SUBMISSION

Address: Nos. 80 – 88 Regent Street, Redfern

Proposal: Mixed Use Development (SSD 7080)

**NOS. 80 – 88 REGENT STREET, REDFERN
PROPOSED MIXED USE REDEVELOPMENT (SSD 7080)**

1 North Elevation
1: 200@A1

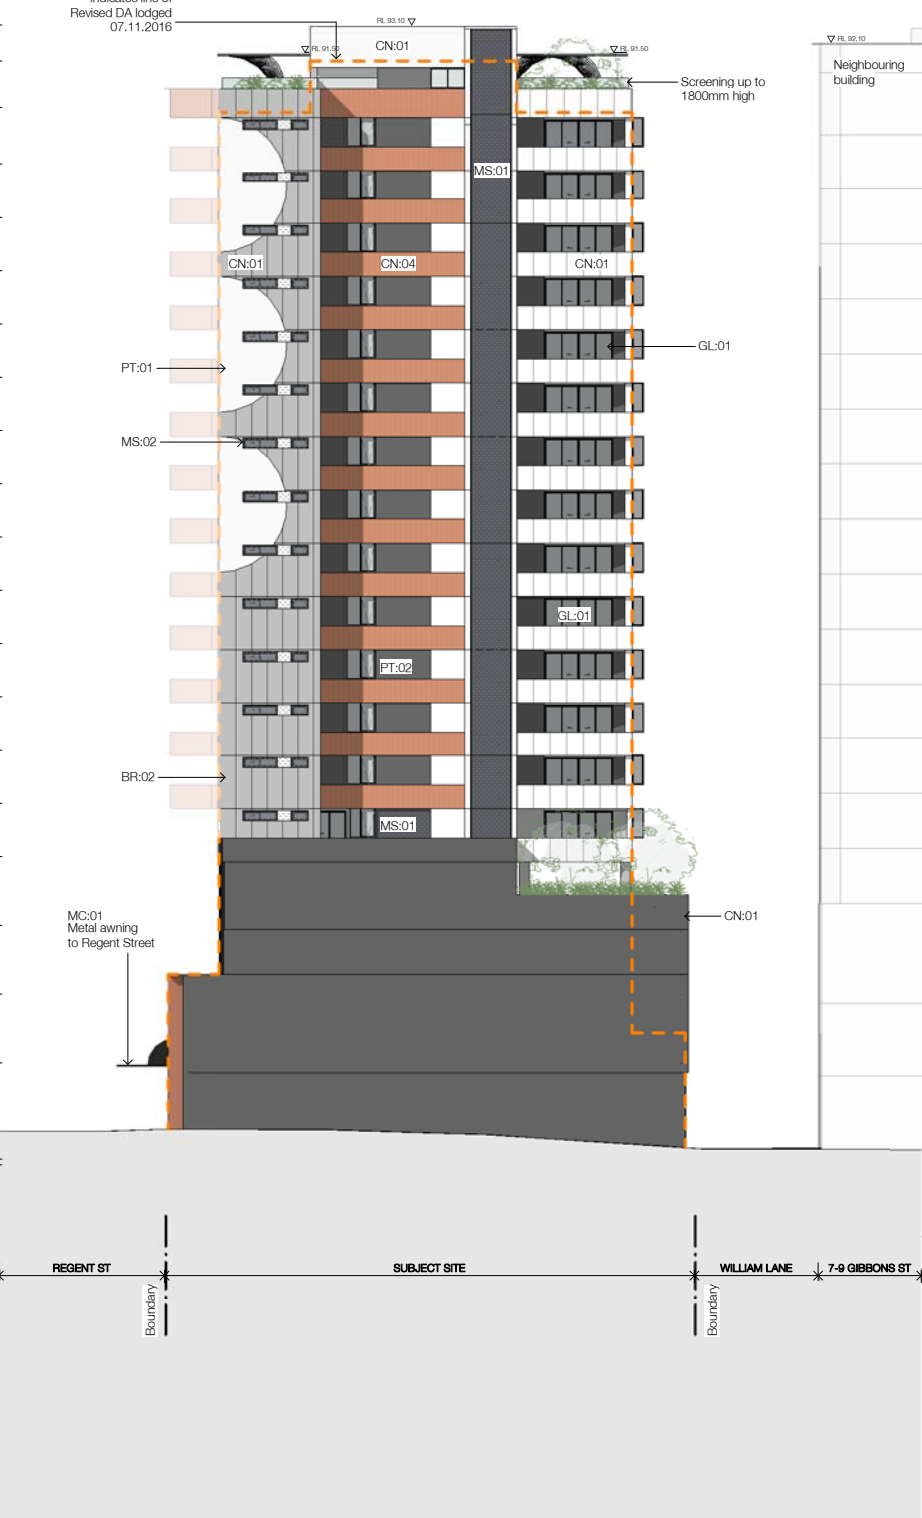
- As habitable rooms are proposed on the southern elevation of the proposed building, a minimum 6 metre setback would therefore be required to the site's Marion Street frontage to all apartments 9 storeys and above to ensure equitable separation between the north facing habitable rooms of any future development on No. 90 Regent Street, accounting for the Marian Street road width.

- Balconies and habitable rooms of the proposed development are currently within the 4 metre Marian Street setback prescribed by the Guidelines, and within the recommended separation distances espoused by the ADG for buildings in excess of 8 storeys.

- This is unacceptable, as it seeks to 'borrow amenity' from No. 90 Regent Street.
- The reduced setback consequently compromises privacy and solar access to any potential future development that includes No. 90 Regent Street.
- It is suggested the 4 metre setback above the podium level to Marian Street should be strictly applied to maximise opportunities for privacy separation between these buildings and solar access to the north face of the proposed future development at No. 90 Regent Street.

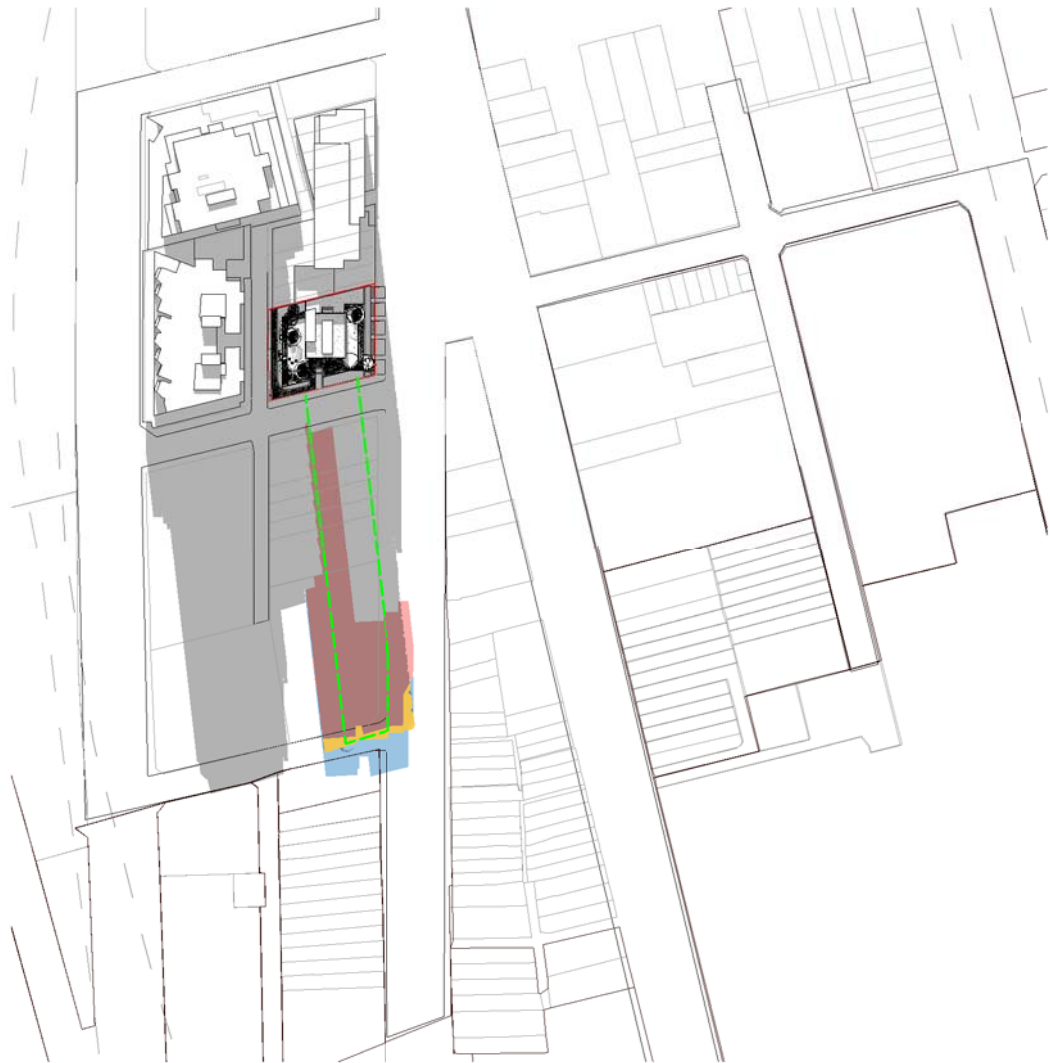
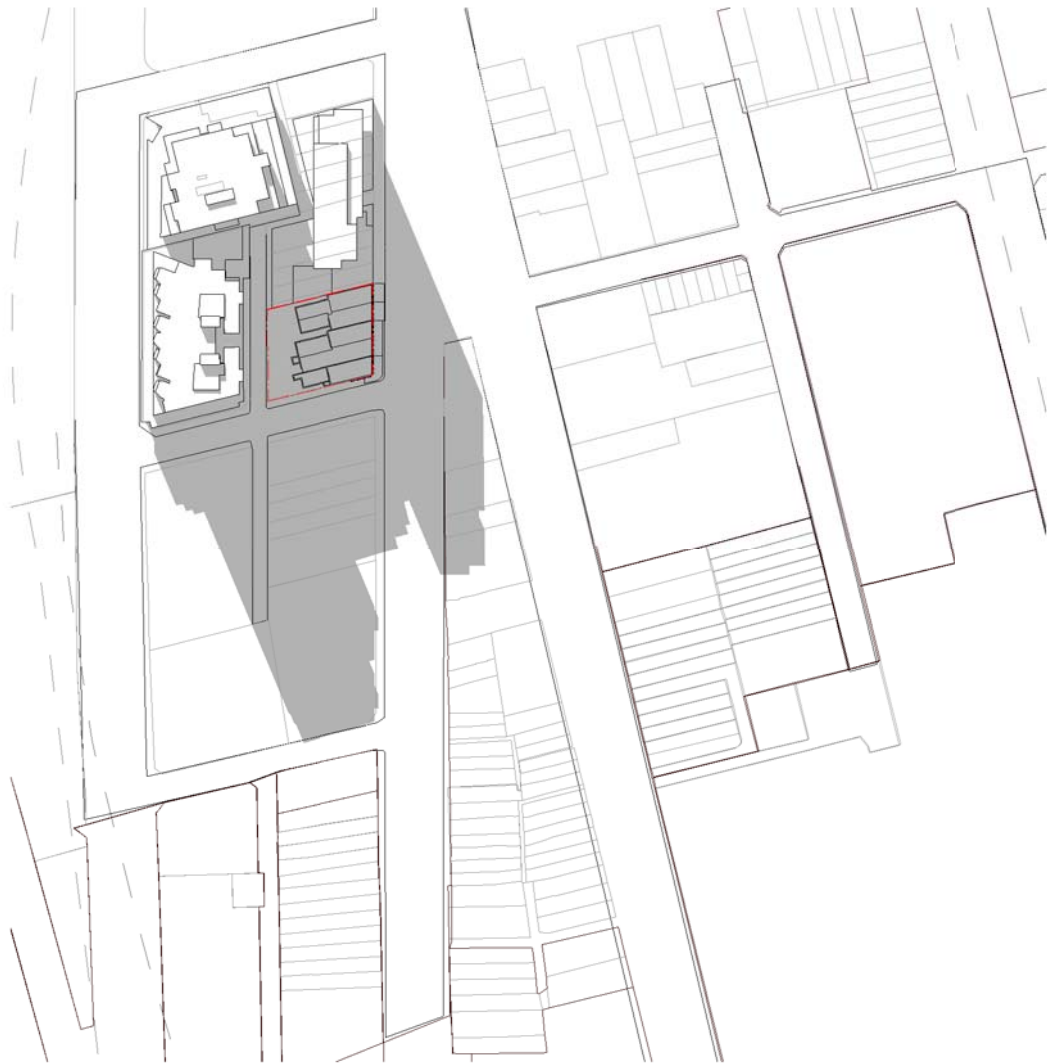
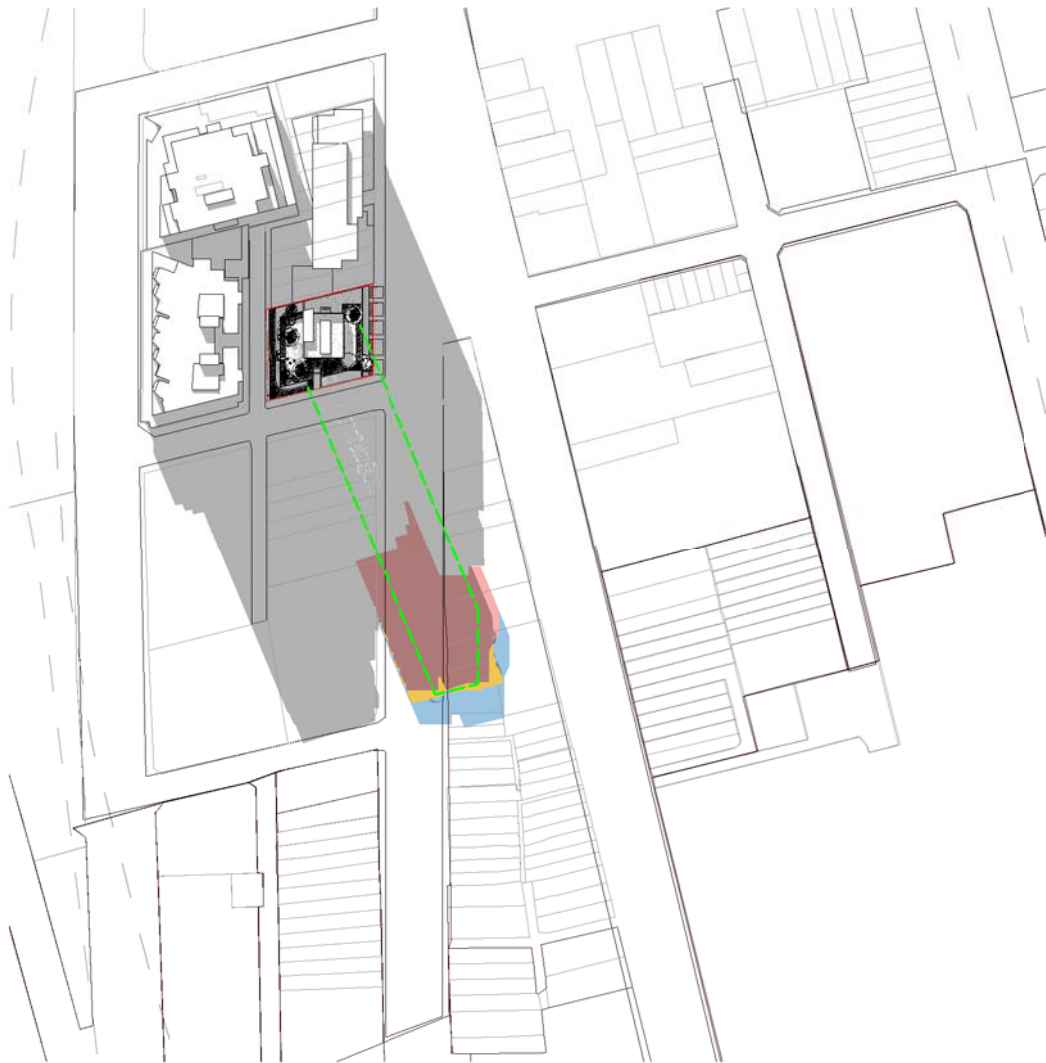
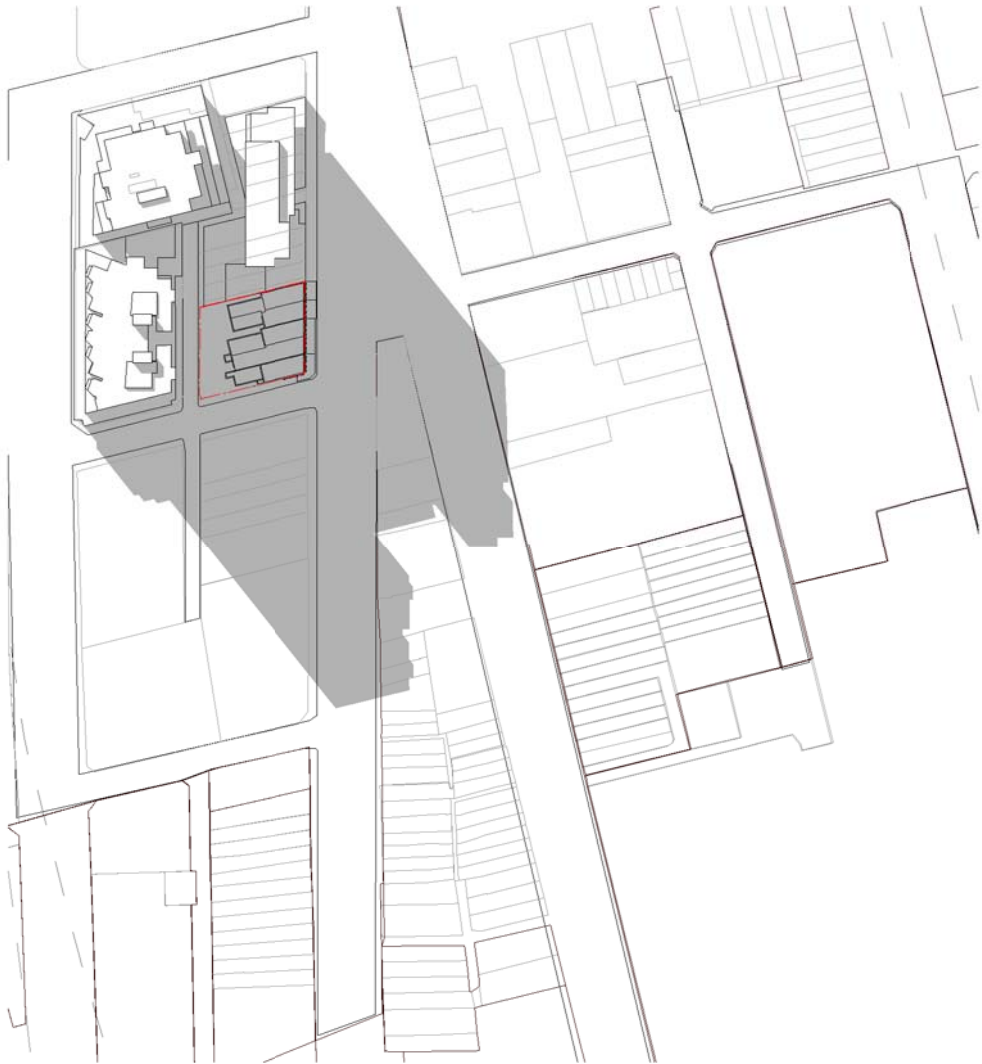
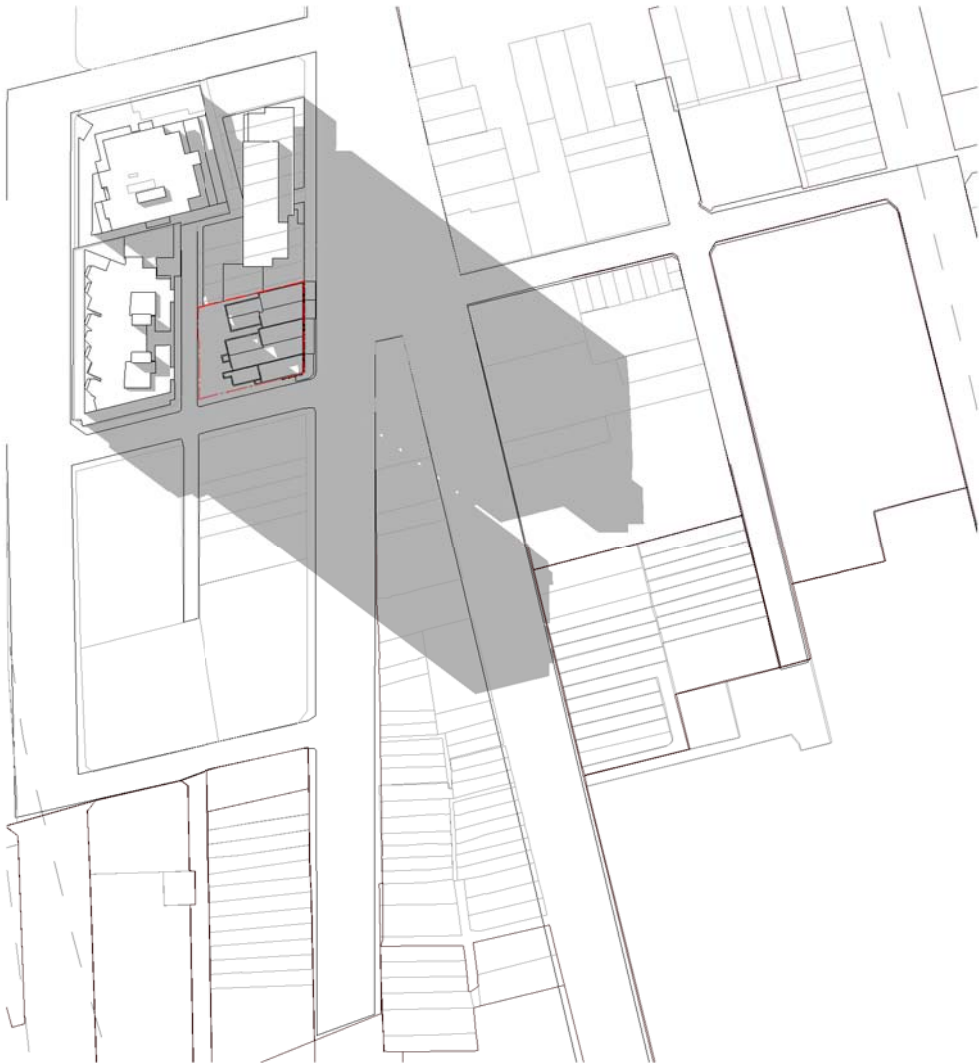
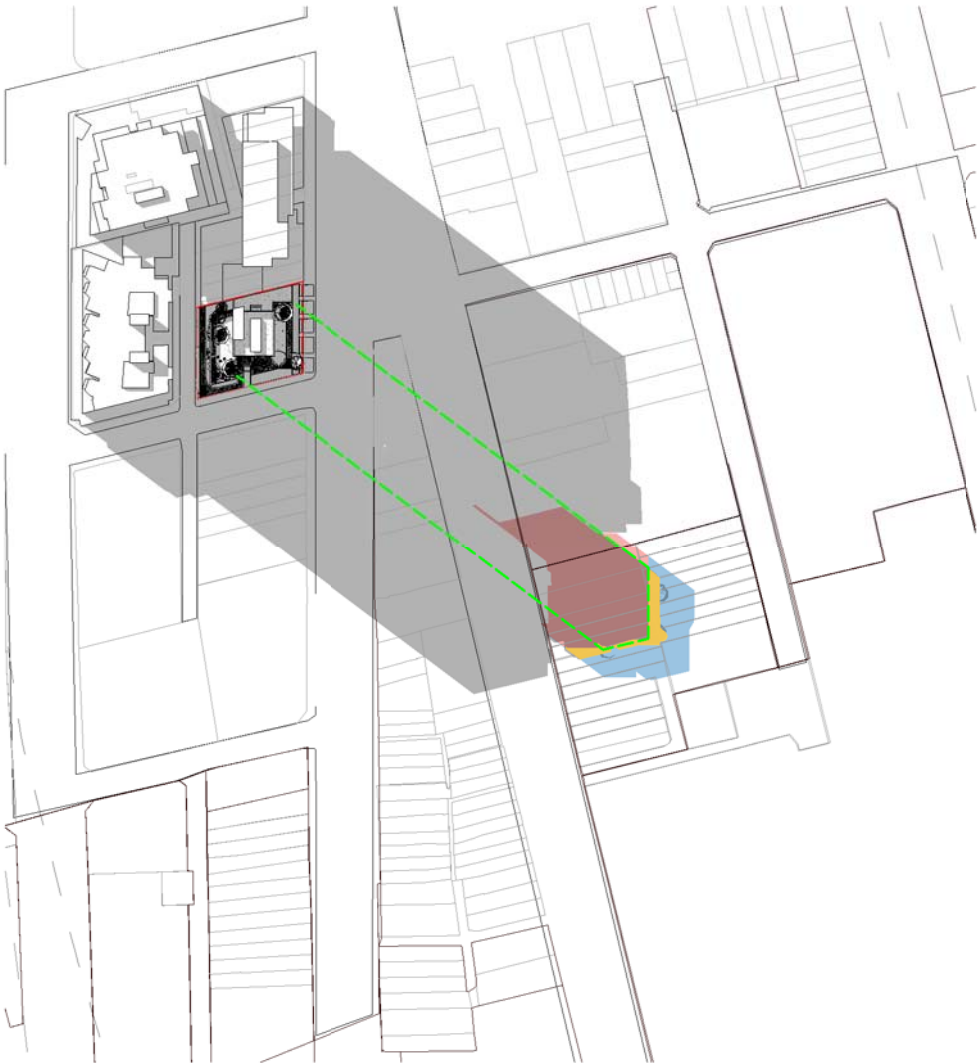
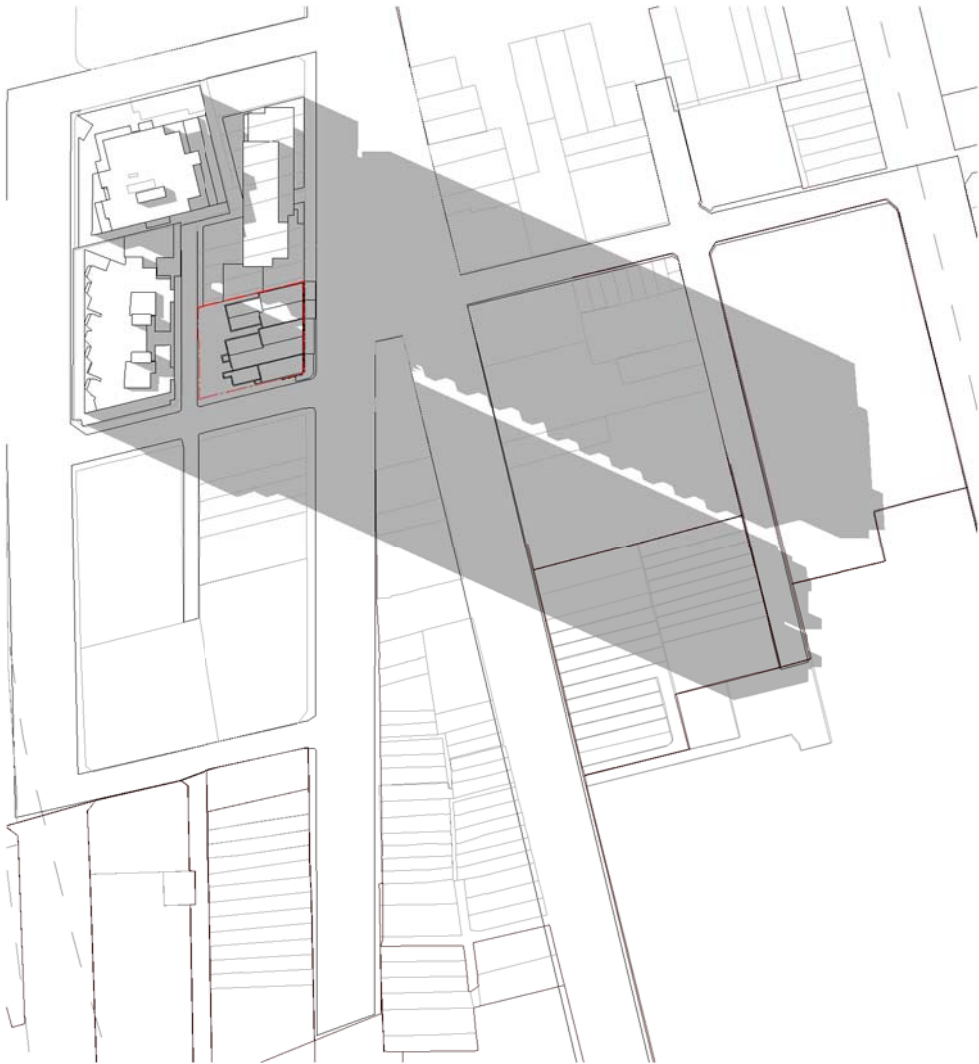
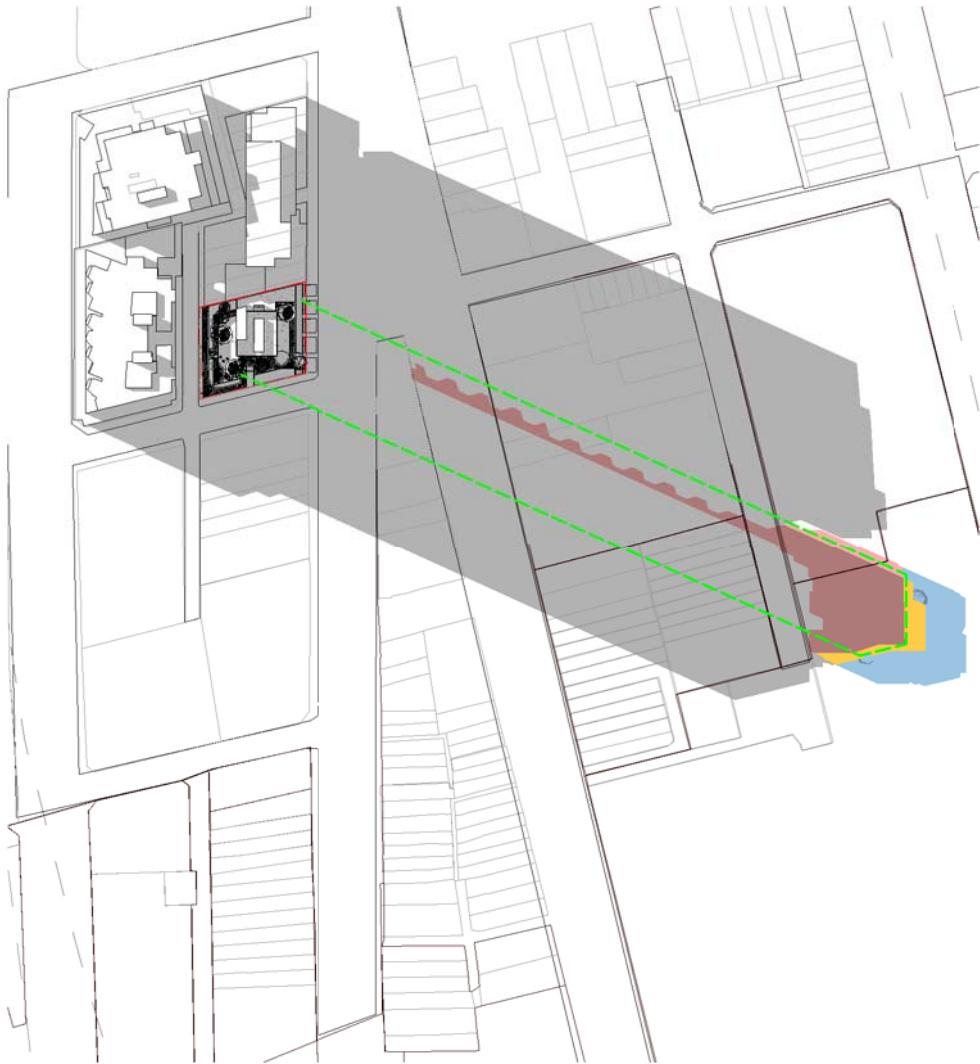
- In areas undergoing change, the impact on what is likely to be built on adjoining sites should be considered. The 'shadow analysis' and 'view from the sun' diagrams fail to take account of a likely building envelope/facade to be constructed upon No. 90 George Street, to enable a determination of the likely impacts of the proposed development upon a compliant building form.

- The combination of reduced setbacks to Regent Street and Marian Street will each have consequential impacts on the ability of Nos. 90 – 102 Regent Street to receive sunlight at mid-winter. Overshadowing arising from any non-compliance with prescribed development controls is generally considered unacceptable in the application of planning principles.

- The shadow analysis and view from the sun diagrams do not contemplate a 'compliant' building that is limited to either 6 storeys in height, or setback 8 metres from Regent Street, which would provide the greatest possible amenity to the future development of No. 90 Regent Street.
